CITY OF ALBUQUERQUE

November 11, 2011

**Re: Volcano Heights Drainage Compilation Report, Engineer's Stamp
Dated 10-24-2011 (C10/D000)**

Based upon the information provided in your submittal received 10-25-11, the above referenced report is approved based on the following comments:

Drawing file: FINAL / VH PLATE 1.pdf

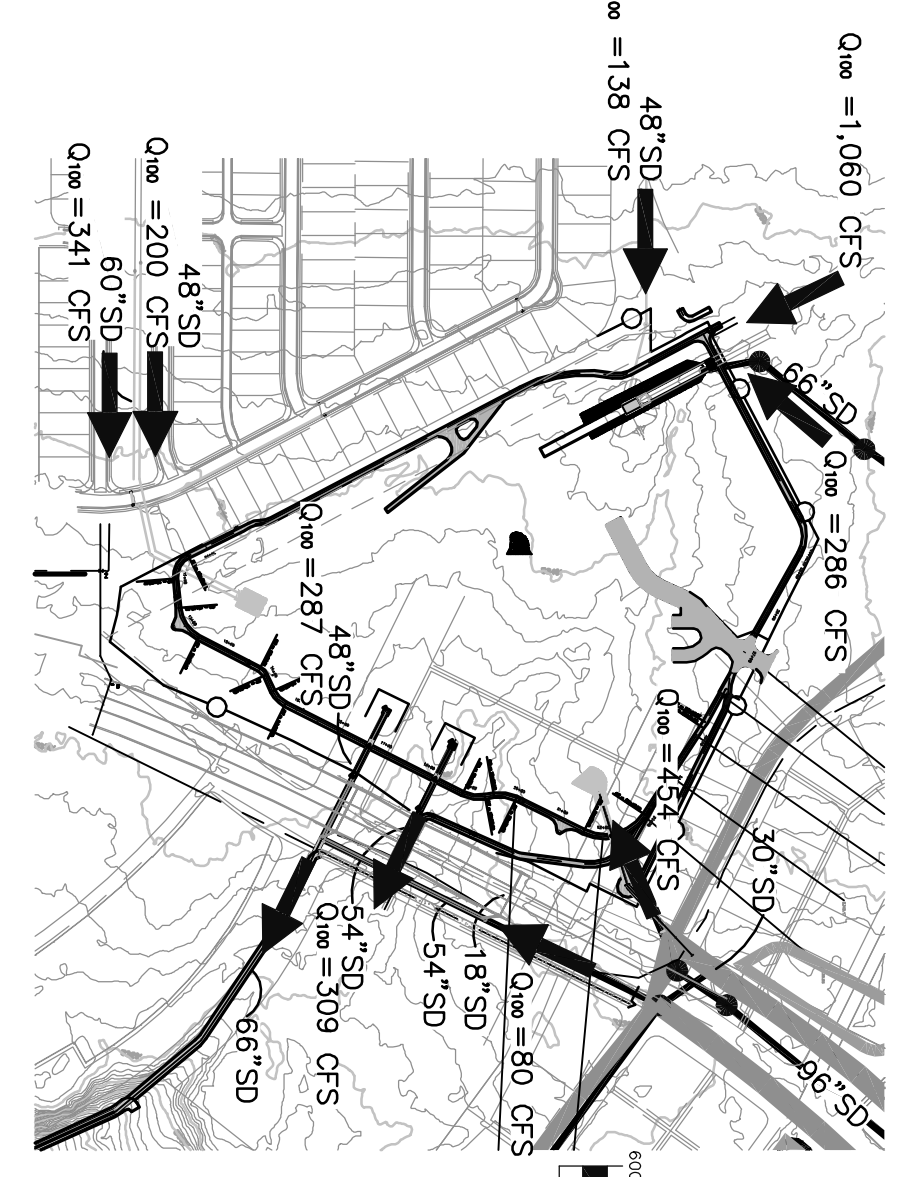
| Albuquerque | • Provide design and details for any discharge to the Petroglyph National Monument to minimize erosion. |
| | • Same Basin Numbers to be used for drainage analysis of future developments within the limits of Volcano Heights Drainage Compilation Report. |
